# East Anglia ONE North and East Anglia TWO Offshore Windfarms

## Applicants' Responses to Examining Authority's Written Questions 3

### Volume 7 – 3.10 Landscape and Visual Impact

Document Reference: ExA.WQ-3.D10.V1\_07

Figure: 29.37e
Viewpoint 5: Public Right of Way, near Moor Farm

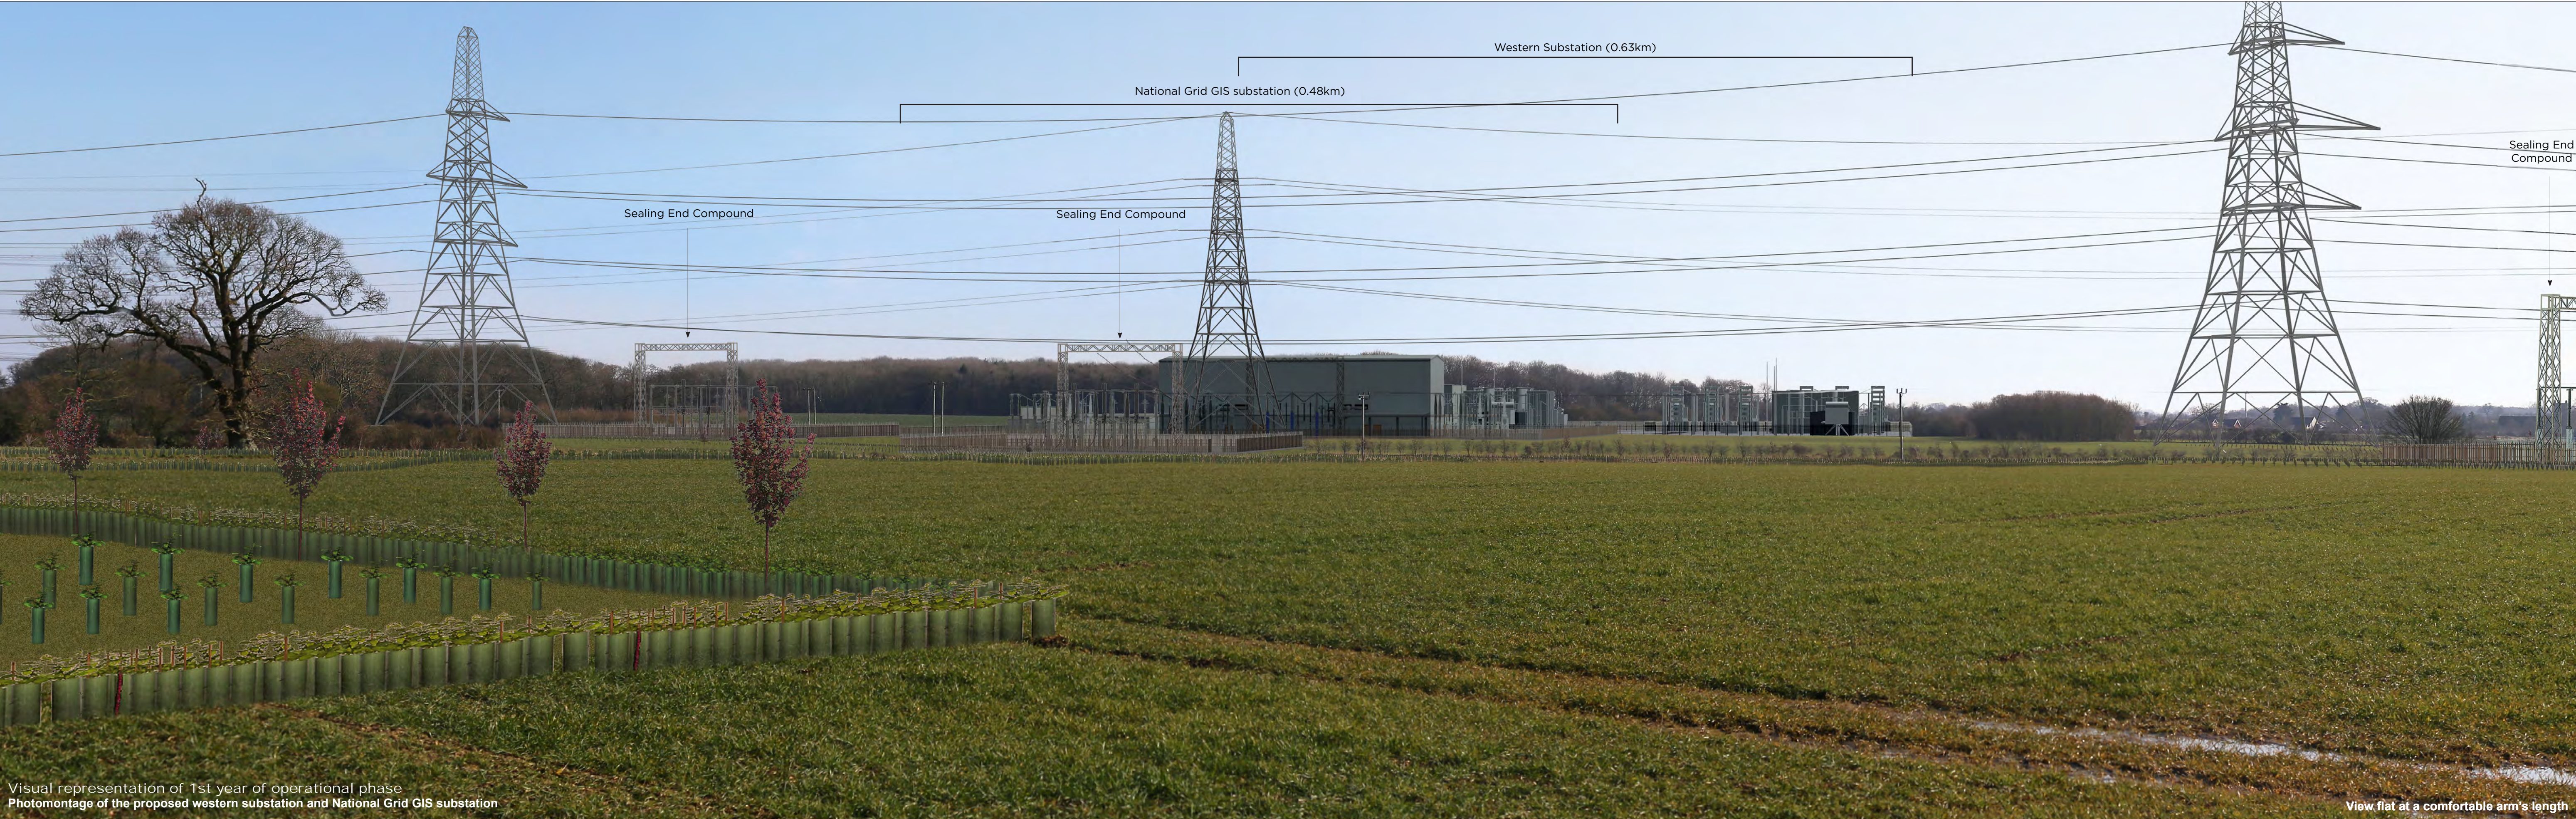
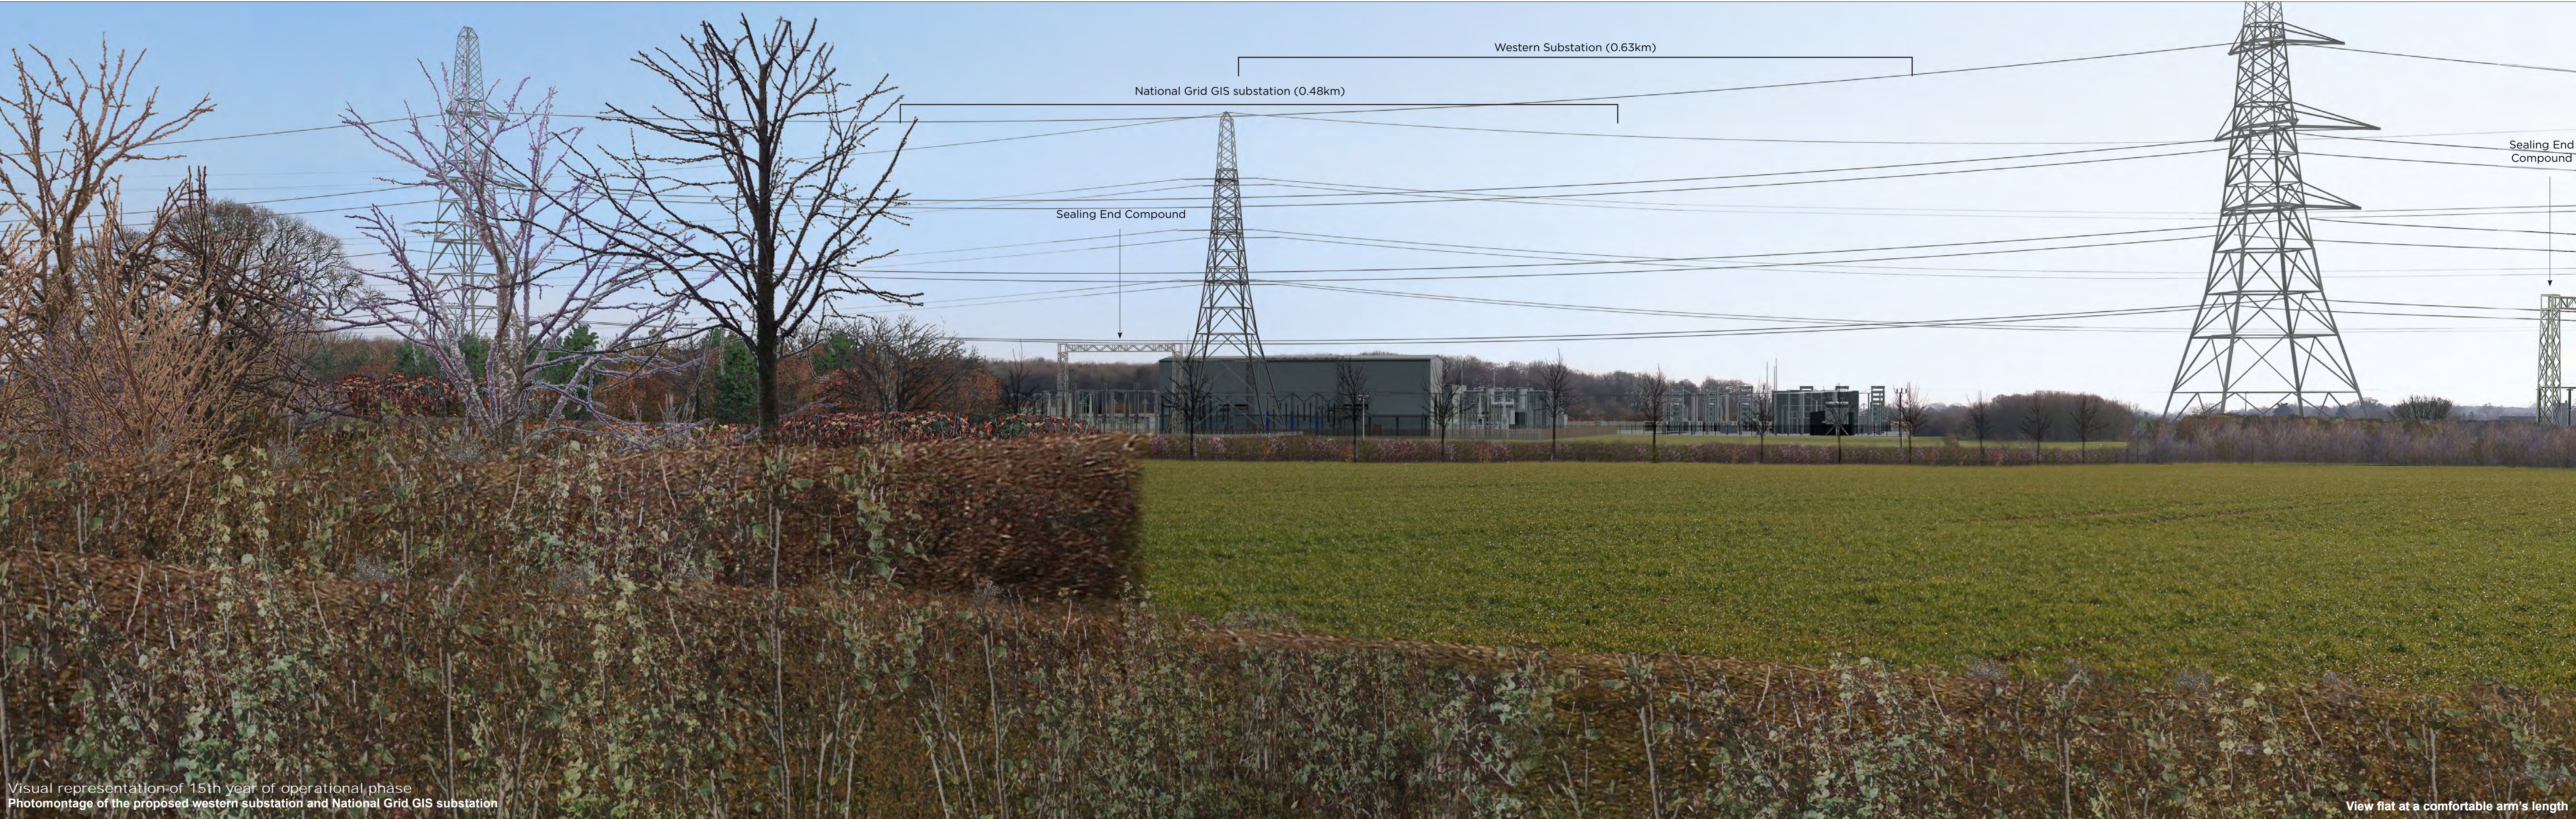
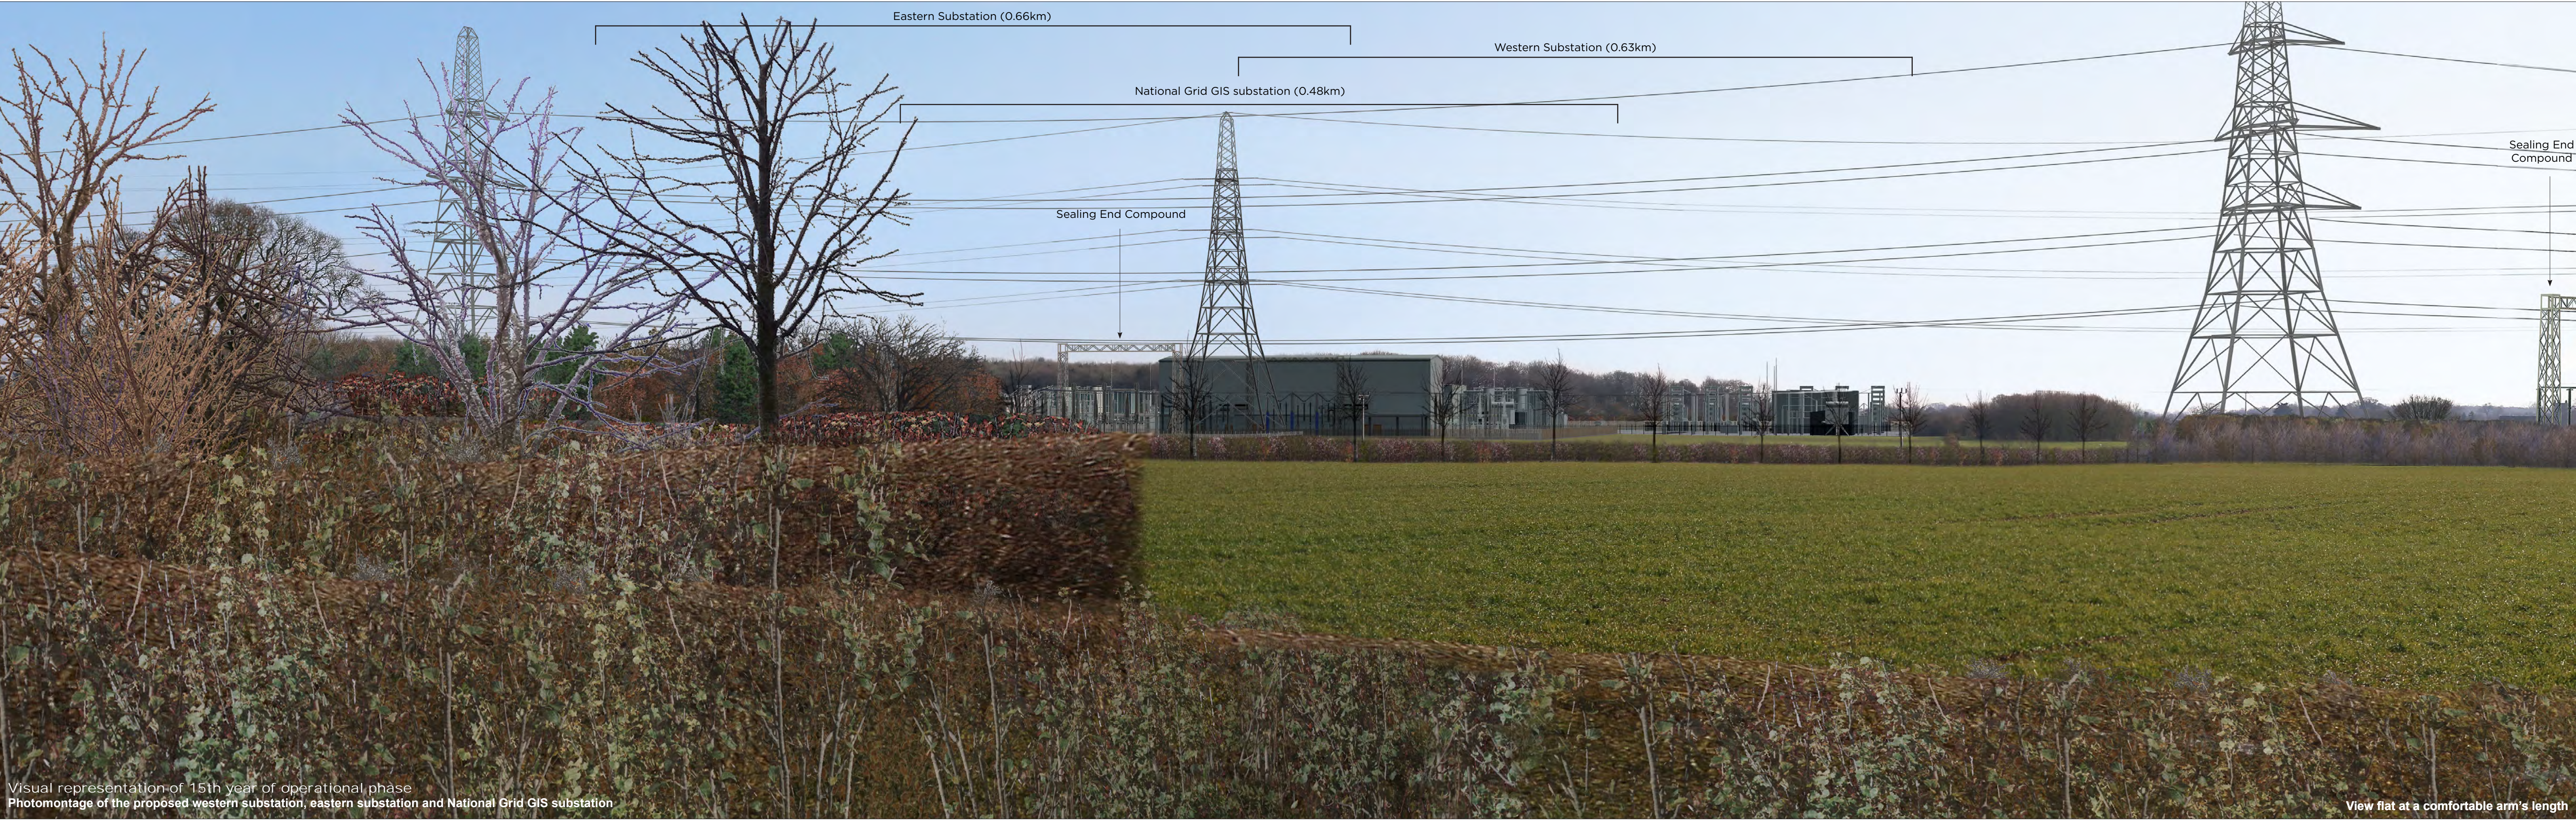
3.10.2	The Applicants	<p><b>OLEMS</b></p> <p>Your answer to ExQ2.10.5 [REP6-063] relates to planting and High House Farm. The ExAs note that you are seeking to balance the proposals in trying to not enclose historic farms while mitigating visual effects on people living in the area. Your answer states that the proposed planting close to the south western boundary of High House Farm is adjacent to existing woodland within the curtilage of this property. An annotated aerial photograph is submitted as part of the answer to demonstrate this point.</p> <p>However, the ExAs noted on their site visits [EV-007d, and as referred to in ExQ2.8.2] that the garden of High House Farm provided clear views across a largely open landscape to the Church of St Mary. This effect was increased by the removal of various ash trees in recent</p>	<p>The Applicants agree that the OLEMS (REP10-005) includes planting proposals adjacent to the southern boundary of the grounds of High House Farm. The new planting area proposed by the Applicant close to the south western boundary is proposed to provide additional screening of views to the south where the sealing end compounds will be sited.</p> <p>The Applicant notes the recent removal of various ash trees due to disease, which has resulted in more open views than at the time of the original assessment. The Applicant noted a mature vegetated boundary to the south-west of the property near Landscape Visual Impact Assessment (LVIA) Viewpoint 5 during its site survey work in the area in February 2019 (see photo below), which it considered would provide some screening and a basis from which to justify further planting around this boundary.</p>

ExA. Question Ref.	Question addressed to	ExA. Question	Applicants' Response
		<p>times due to disease [referenced in EV-007d] which would likely change the aerial photograph were it to be taken now.</p> <p>Given this do you wish to add to your answer ExQ2.10.5?</p>	<p>It is clear that trees were located to the south of the farm both historically (OLEMS Figure 1 (REP10-005)) and recently until their felling due to decline as a result of Ash dieback. Such trees would have prevented or filtered views to the south. The proposed woodland area alongside this would seem to be an appropriate bolstering of such a design intent however, the Substations Design Principles Statement (document reference ExA.AS-6.D11.V3) sets out that consultation with local residents will be undertaken to discuss their expectations for landscape work in the vicinity of their properties and this will be taken into account subject to agreement with other stakeholders. The OLEMS has been designed in outline to ensure that an appropriate framework is delivered. The Applicants recognise that this will have to balance various interests. It is important that there is a proper process to enable this to be done in a transparent way. The design process secured through the draft Development Consent Order (DCO) will facilitate this.</p>
